City of Albuquerque Stormwater Construction Site Inspection Report

General Information				
Project Name:	Murphy's Express			
Location:	3751 Hwy 528			
Site Contact Name & Agency	Dominic Fulginiti	ESC File No.	A11E003A	
	JMD Construction Svcs.	NPDES Id. No.		
Inspection Date:	02/20/19	Start/End Time:	0740/0830	
CoA Stormwater Inspector:	Timothy Sims, Stormwater Inspector			
Present Phase of Construction:	landscaping and some flat work			
Type of Inspection:	<input type="checkbox"/> Regular	<input type="checkbox"/> Storm Event	<input type="checkbox"/> Post Storm Event >0.25"	<input checked="" type="checkbox"/> 311/Complaint <input checked="" type="checkbox"/> Follow Up

C-3

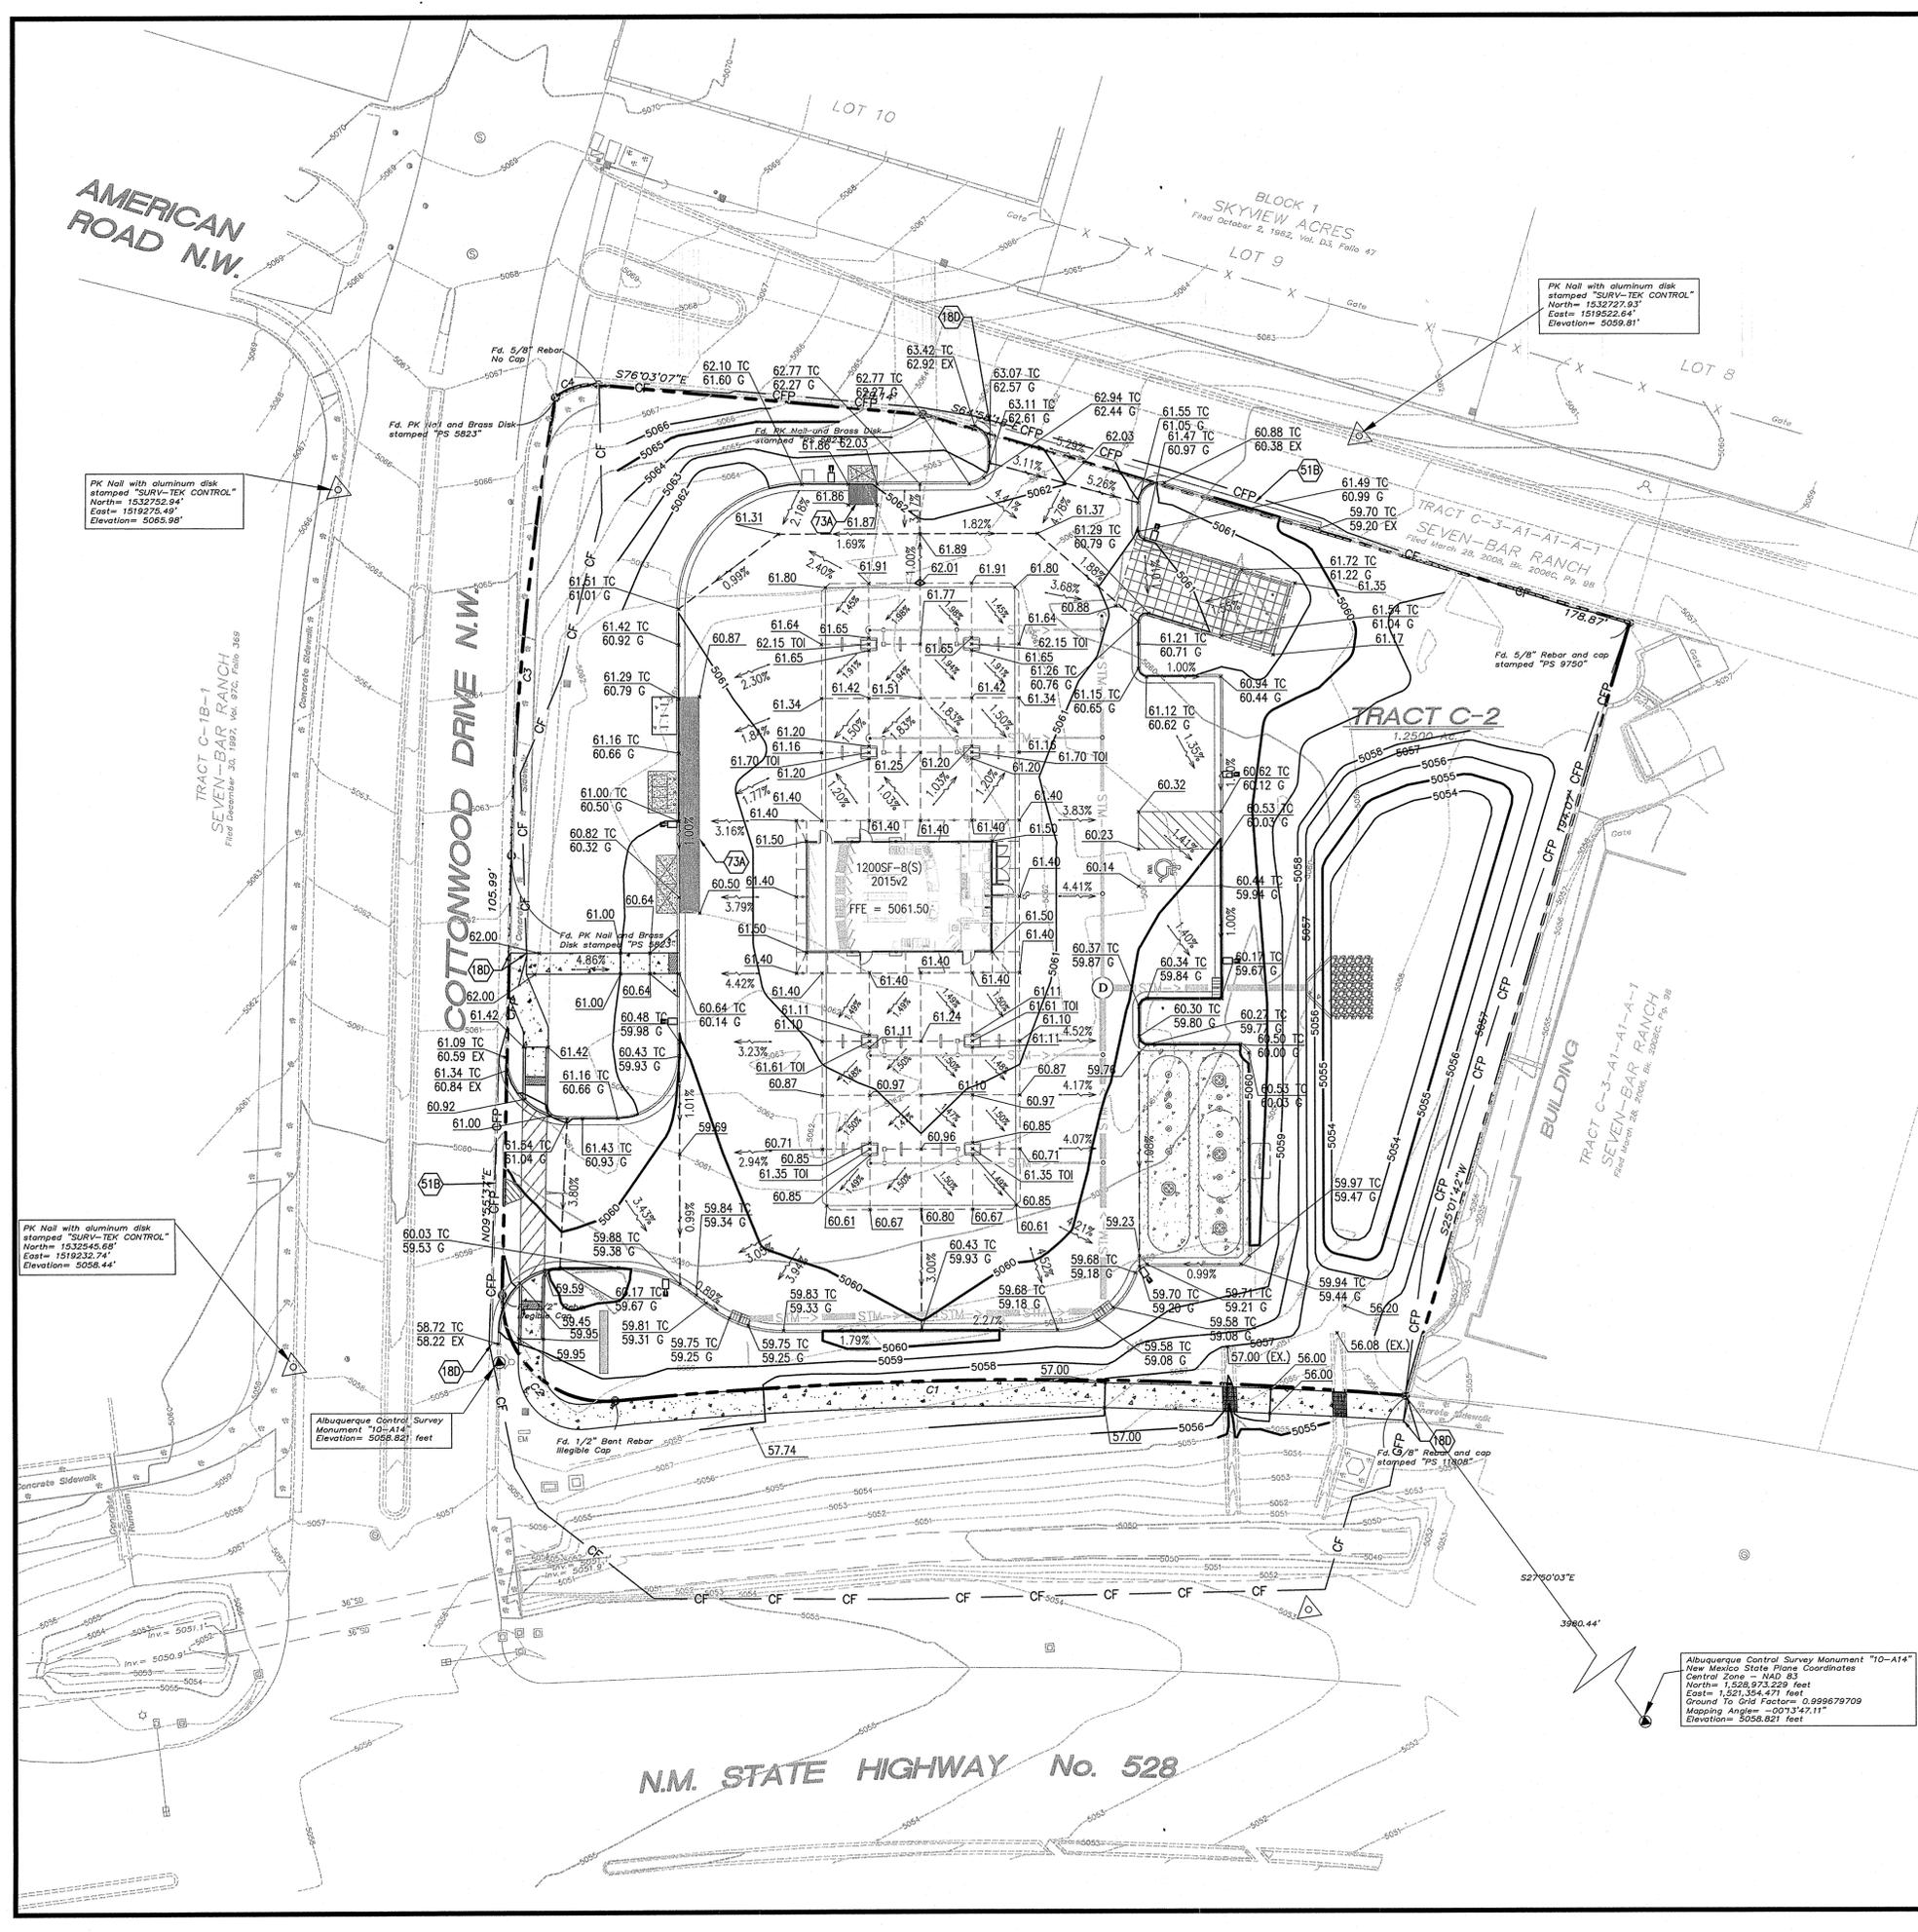
Inspection			
CGP Section	BMP / Activity	Maintenance or Corrective Action Required	Location and Notes
1.5	Post a Notice	x	Provide NOI number and posting to public R.O.W.

2.2.1	Provide and maintain Natural buffer when Waters of the US <50ft.		
2.2.3	Sediment control along any perimeter	x	re establish east sediment BMP at wall

2.2.3	Sediment control along any perimeter	x	re establish S. east sediment BMP @ property line
2.2.3	Sediment control along any perimeter		
2.2.3	Sediment control along any perimeter
